**Our Ref: P/13/13/
Your Ref:**

Application for Planning Permission for Works or Extension to a Dwelling

Development Second storey extension over front porch and rear single storey extension.

Location 45 Kings Drive Bognor Regis West Sussex

PROPOSED SITE PLAN 1:200

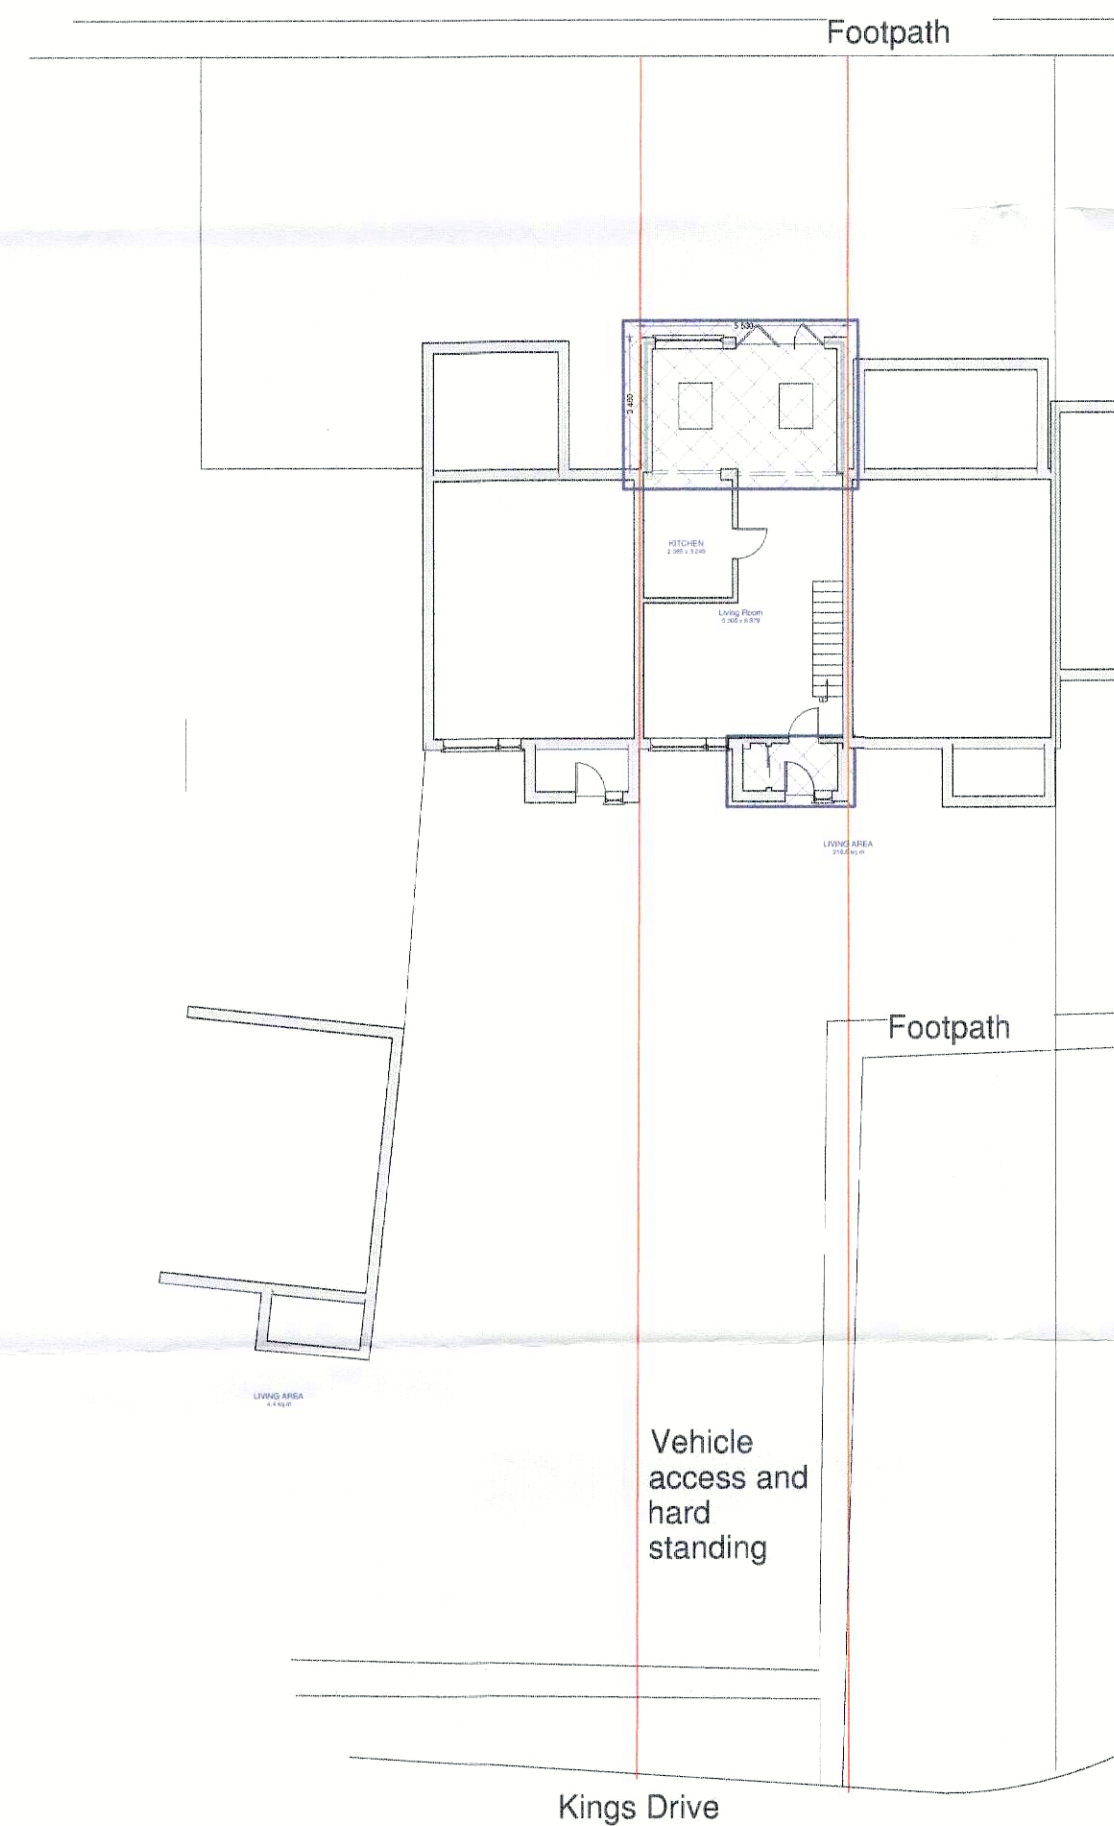
Please submit amended block plans to show the position of the proposed extensions clearly highlighted
